**Hunter Valley Operations South Mod 7 (MP06_0261-Mod-7)
Modification Report**

Attachment A

Detailed advice to DPIE Planning & Assessment regarding the Hunter Valley Operations South Mod 7 (MP06_0261-Mod-7) Modification Report

Conceptual hydrogeological cross section – A-A'

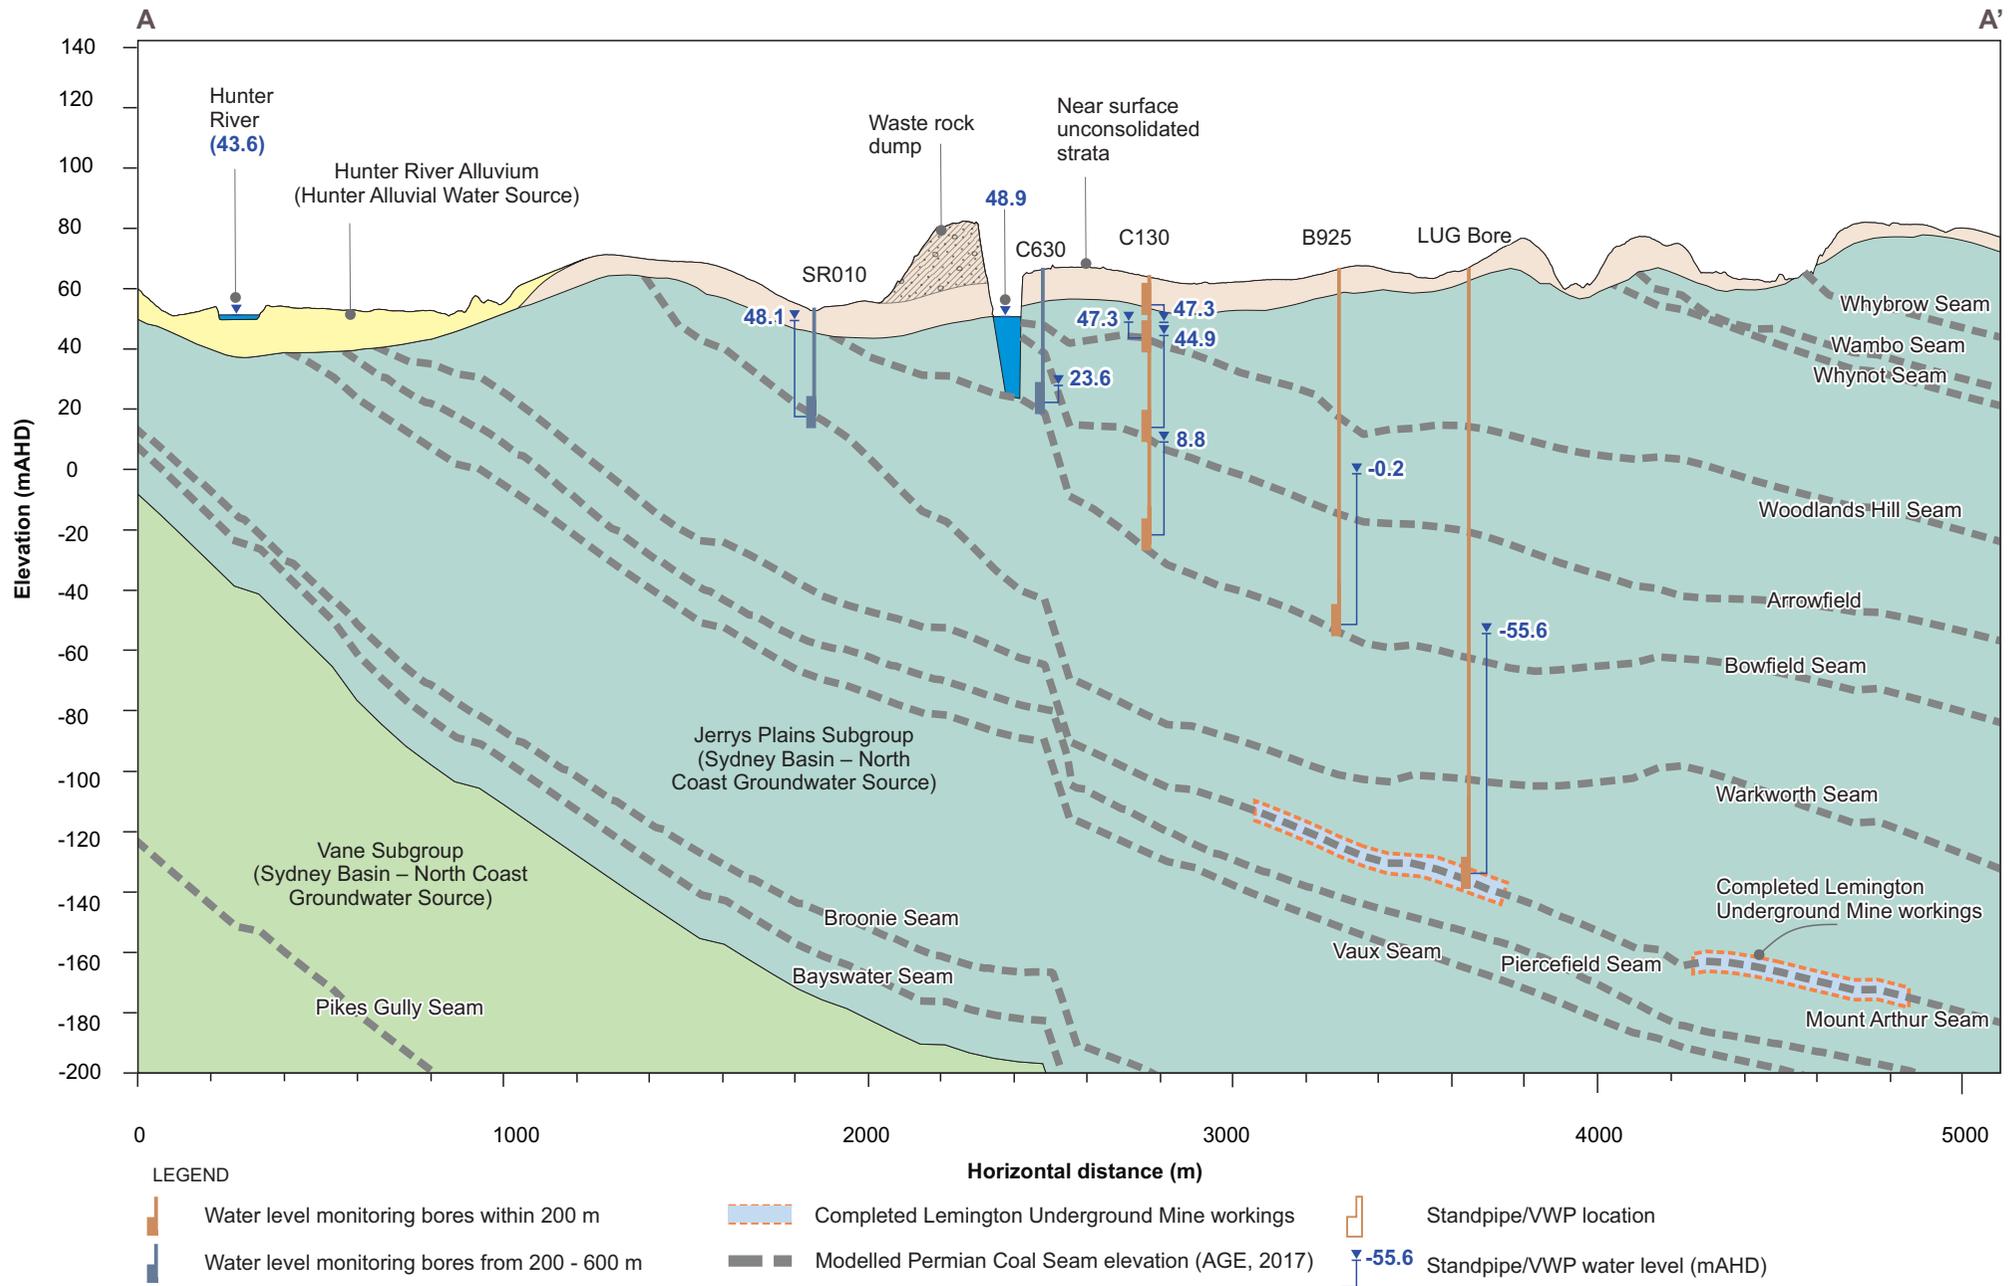
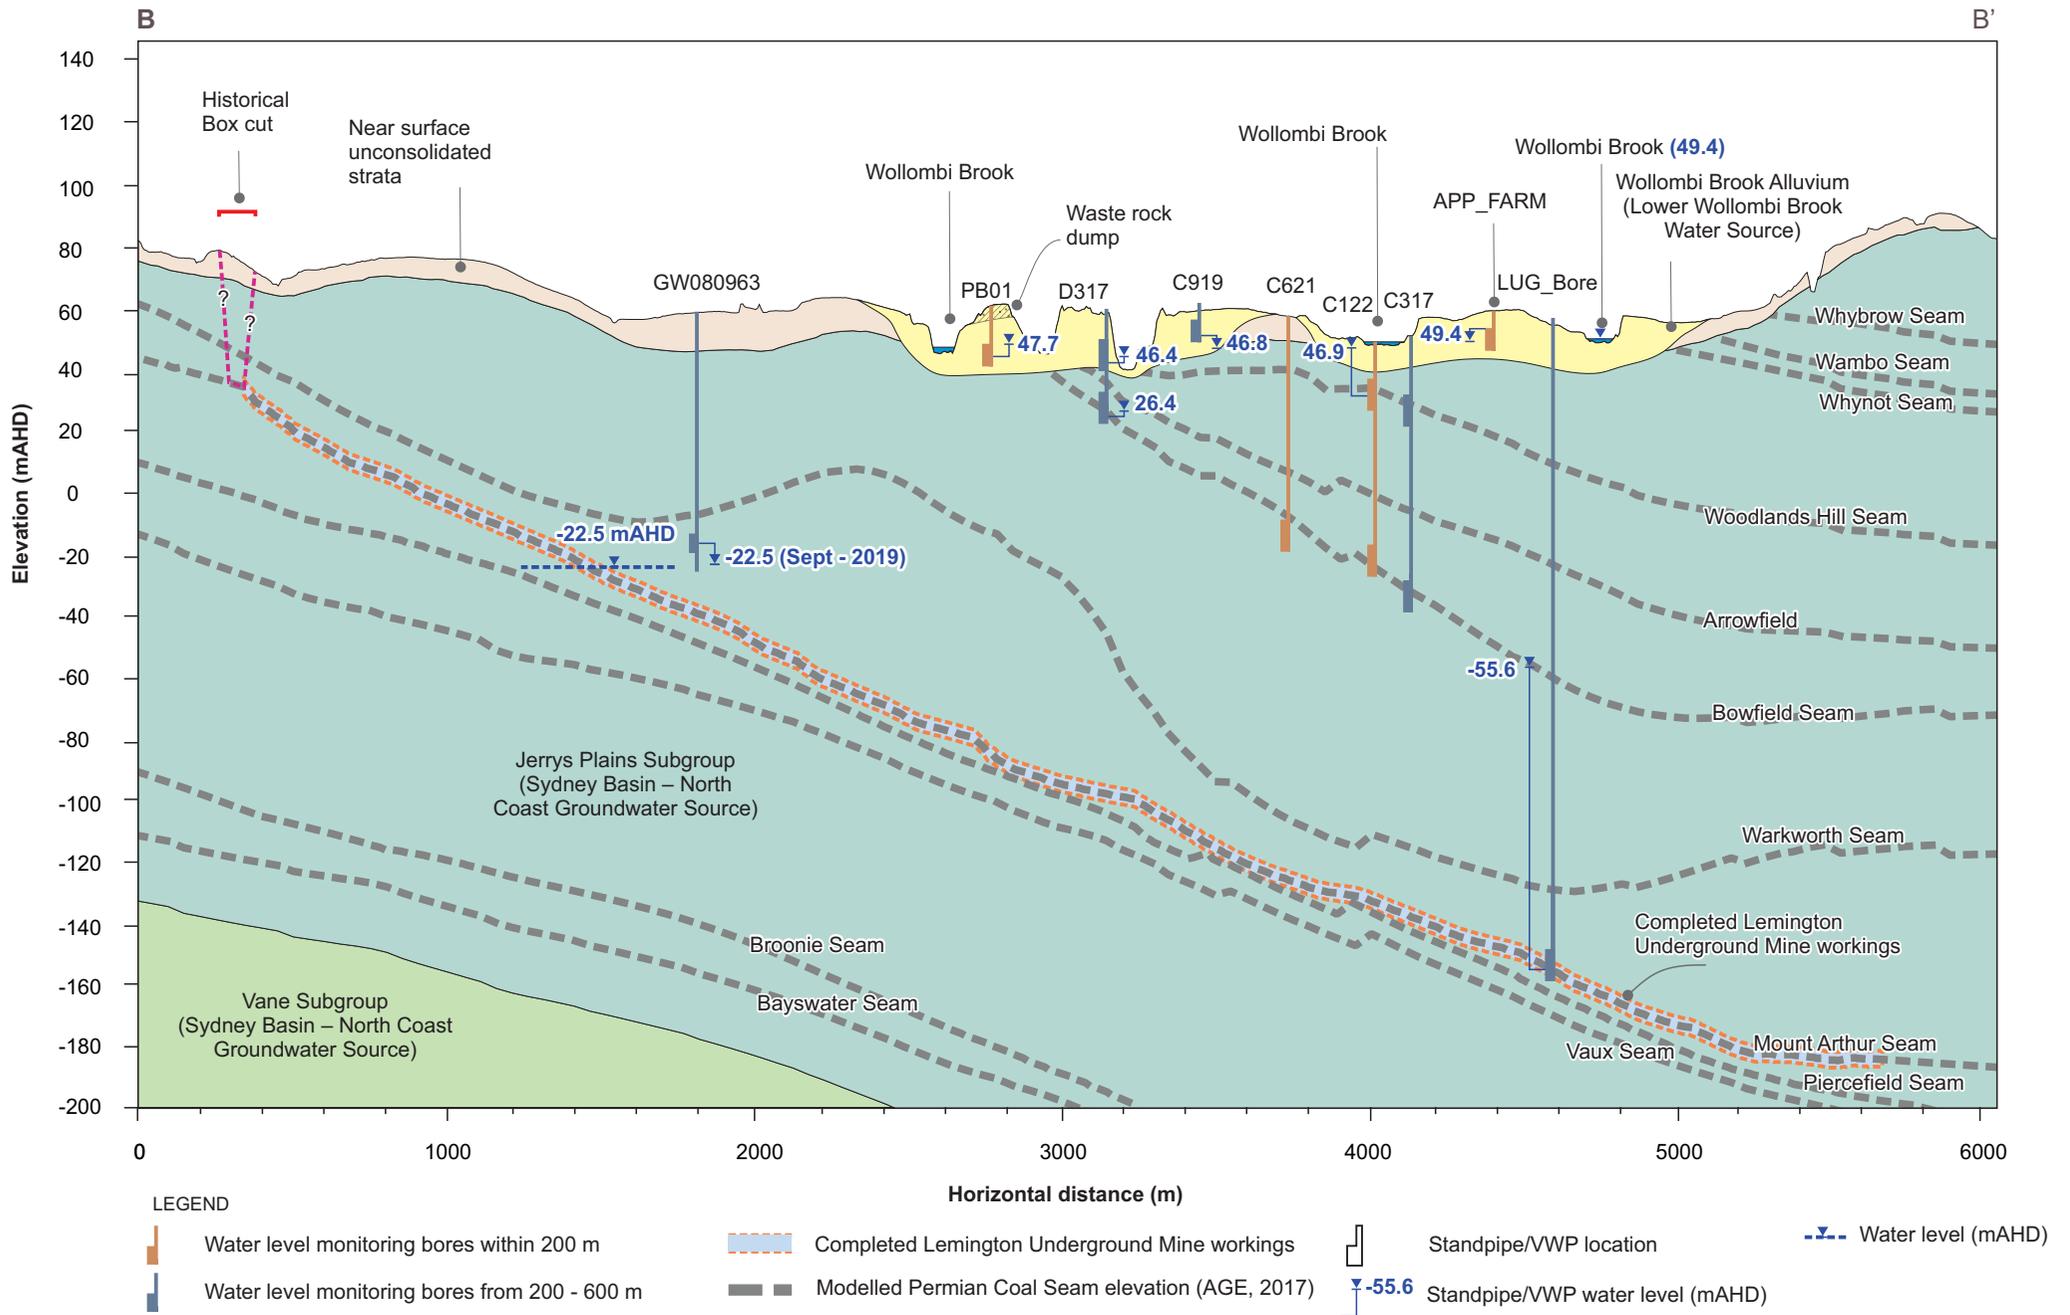
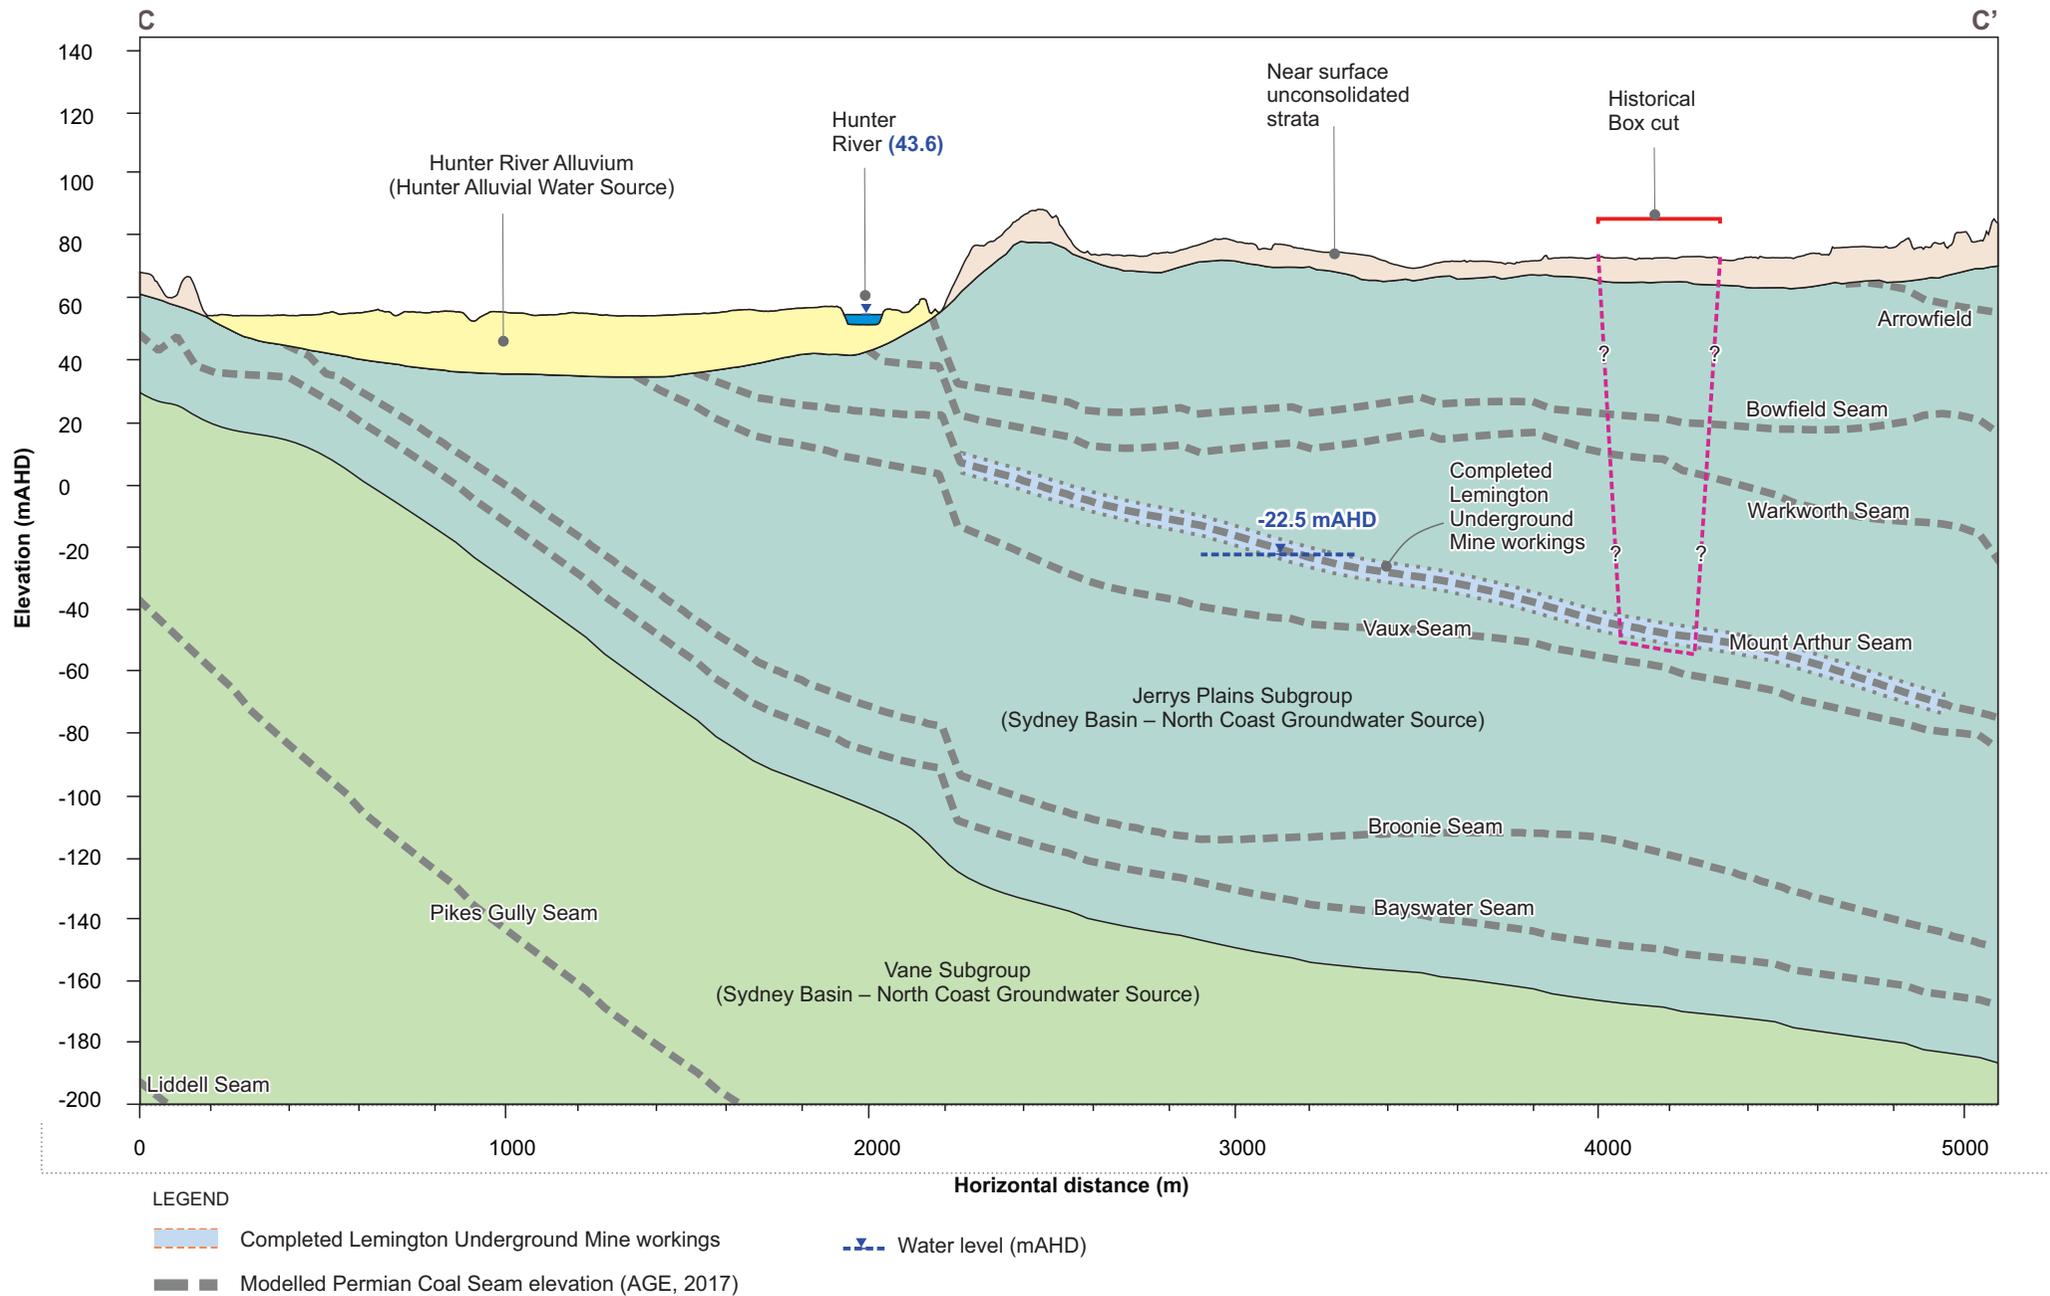
Whilst the conceptual geology cross sections present a base level of around 40 mAHD for the alluvium, it is noted that there are no observation points with drill logs in proximity to the site, nor an inferred mapped extent of the sub-cropping coal seams to reconcile with confidence a buffer separation between the base of the alluvium and nominal fill level.

The thickness of the Hunter River Regulated alluvium is variable and the LUG Bore site abuts a large alluvial meander at the confluence of the Wollombi Brook and Hunter River. The thickness of the alluvium may be greater than conceptualised. There is negligible spatial information on alluvial base in AHD. DPIE Water recommends a conservative fill level be set that maintains at least a 10 m vertical separation to account for spatial variability. The final figure can be revised upon completion of the additional drilling along the north-east corner that informs on the base of the Hunter Regulated River Alluvial Aquifer in proximity to the site and the vertical buffer separation between the alluvial base and the nominal fill level that manages risk of seepage from the LUG water storage to the Hunter River.

- set the proposed maximum fill level at 30 mAHD, and/or a minimum 10 m buffer separation between the base of the alluvium and fill level, whichever gives the greater vertical separation. Final reference level can be revised after the additional drilling is completed.
